The A303 Sparkford to Ilchester Dualling Project case reference TR010036

Long Hazel Park reference 20014098

Written evidence comments and further submissions on behalf of Long Hazel Park arising out of draft SoCG, Applicants Answers to Planning Inspectorates specific Questions relating to traffic noise issues

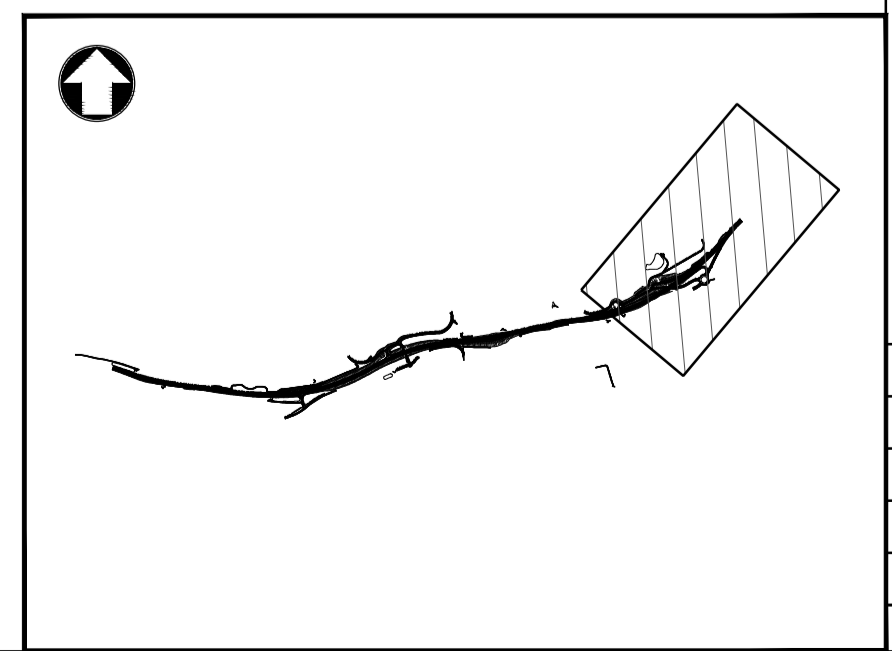
9. We cannot believe that the Applicant evades the provision of at least some sort of lighting in the underpass tunnel at Camel Hill linking Hazlegrove School on alleged financial grounds. In the winter months especially it gets dark around 4pm and daylight returns light around 8am. There will be users in the tunnel when it is dark. Has the Applicant considered a solar system with back up battery and LED lighting? This could be provided for a reasonable cost with very little aftercare and could be monitored remotely. Security and safety of users should come first.
